Appeal Decision

Appeal Ref: APP/R5510/W/25/3369766

Upper Floors and Rear of 122-124 High Street, Ruislip HA4 8LS

- The appeal is made under section 78 of the Town and Country Planning Act 1990 (as amended) against a refusal to grant planning permission.
- The appeal is made by Golds Leisure Ltd against the decision of the Council of the London Borough of Hillingdon.
- The application Ref is 11894/APP/2024/3030.
- The development proposed is the change of use of part of the rear of the building and upper floors from Class E to C3 to create six residential dwellings alongside associated works.

**PROPOSED  
FIRST AND SECOND FLOOR  
PLANS**

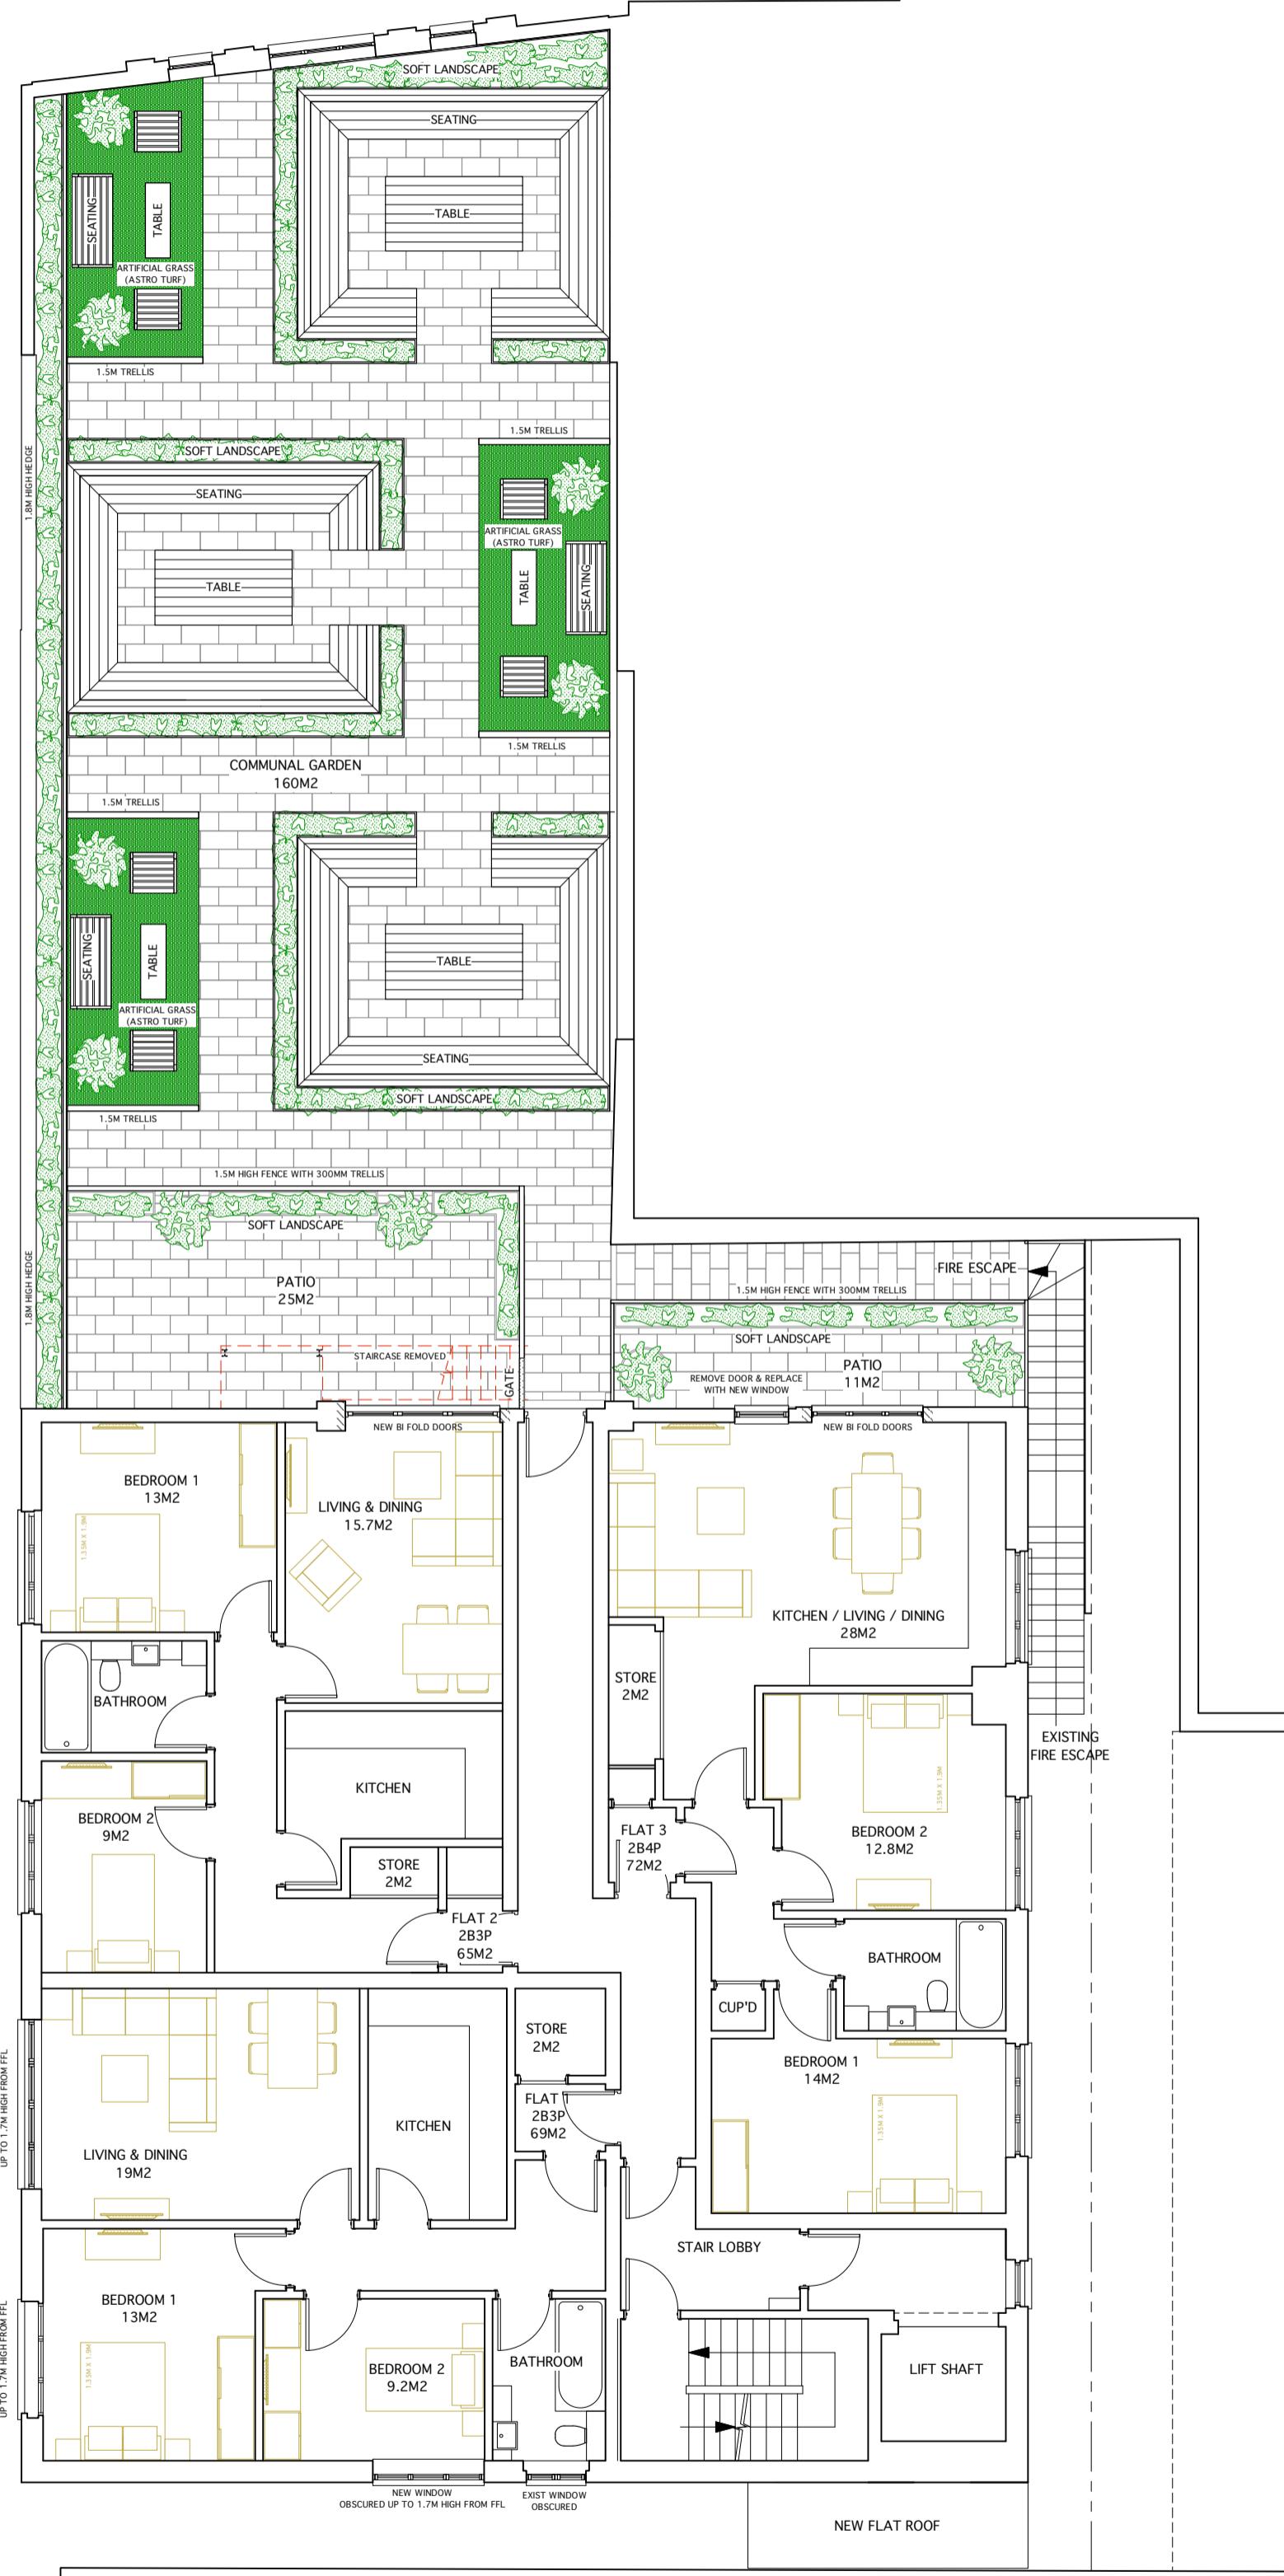
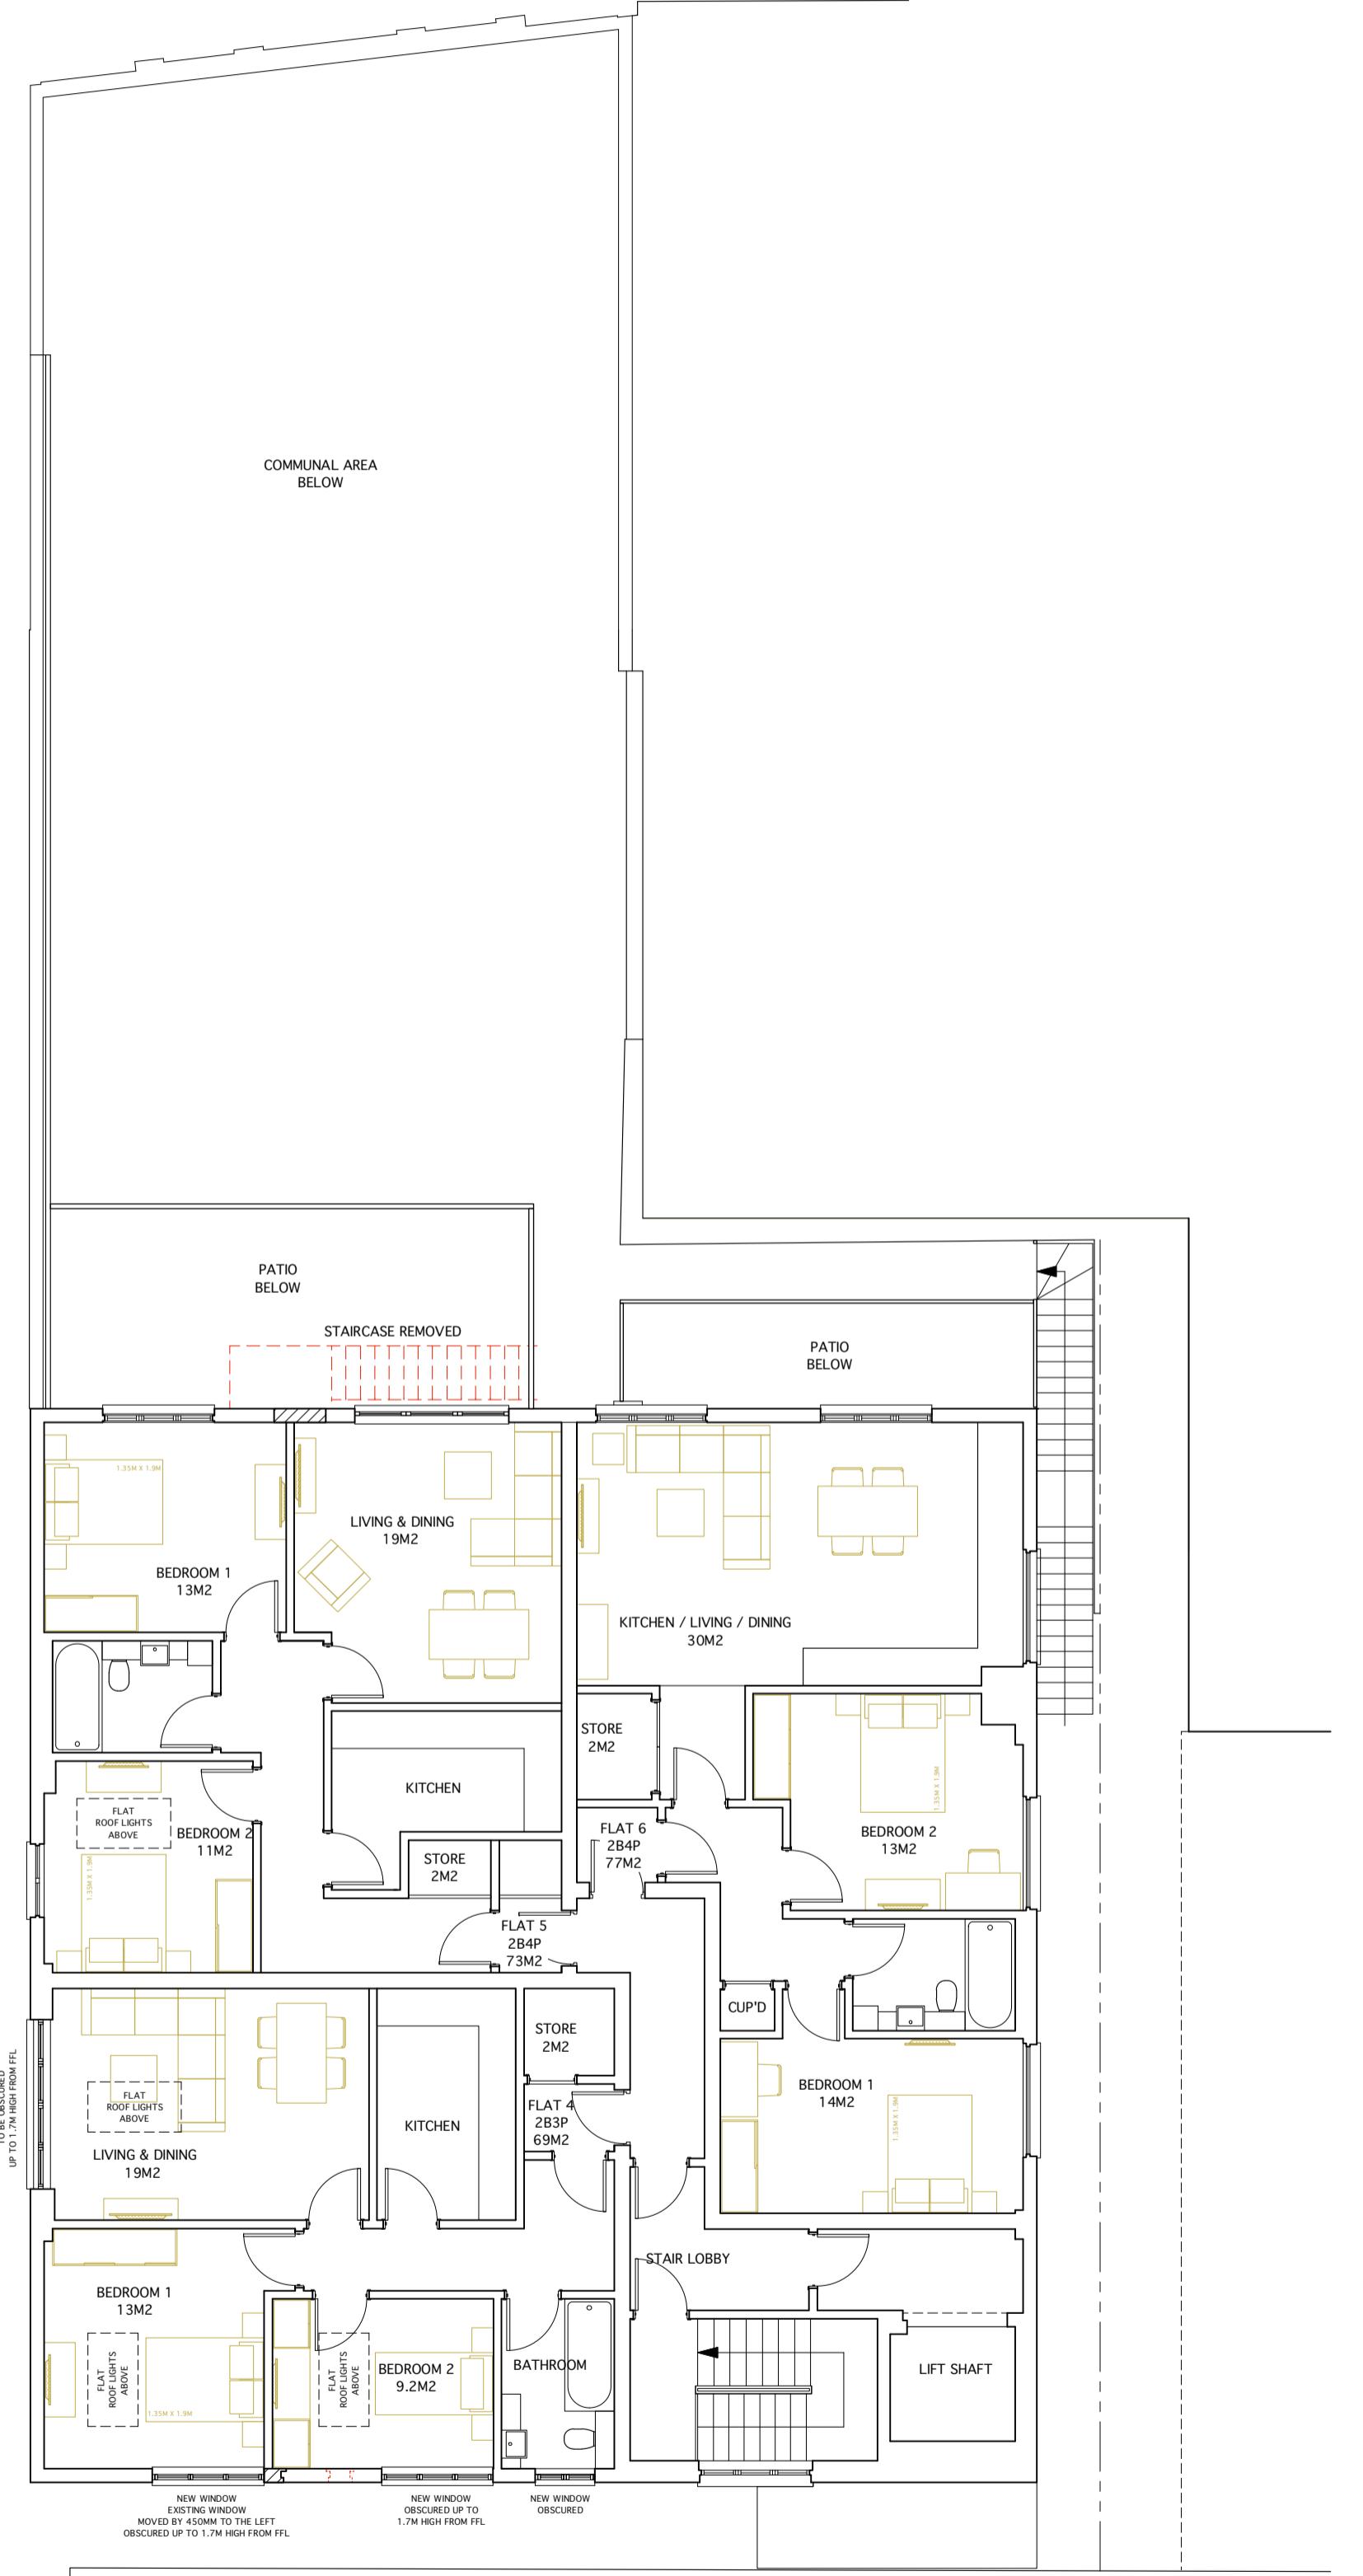
11. The proposed floor plans show that flats 1 and 4 would be dual-aspect units. However, all the windows on these flats, including those serving habitable rooms, would be obscure glazed up to 1.7m above finished floor level. This arrangement would preclude any meaningful views towards the exterior environment. Therefore, future residents would not be provided with an adequate outlook, to the detriment of their living conditions.

12. The appellant has suggested that a condition related to the final window treatments could be imposed, were I minded to allow the appeal. However, doing so would likely modify the development in a way that would make it substantially different from that set out in the application, particularly because clear glazed windows would offer unrestricted views towards the exterior environment. Consequently, I do not find that imposing such a condition would be reasonable.

13. As such, the proposal would fail to provide satisfactory living conditions for the future occupants of flats 1 and 4, with particular regard to outlook. It would be contrary to Policy D3 of the London Plan 2021 (LP) and to Policy DMHB11 of the London Borough of Hillingdon Local Plan Part 2 - Development Management Policies 2020 (DMP) which among other things support development that designed to highest standards and is of the most appropriate form for the site.
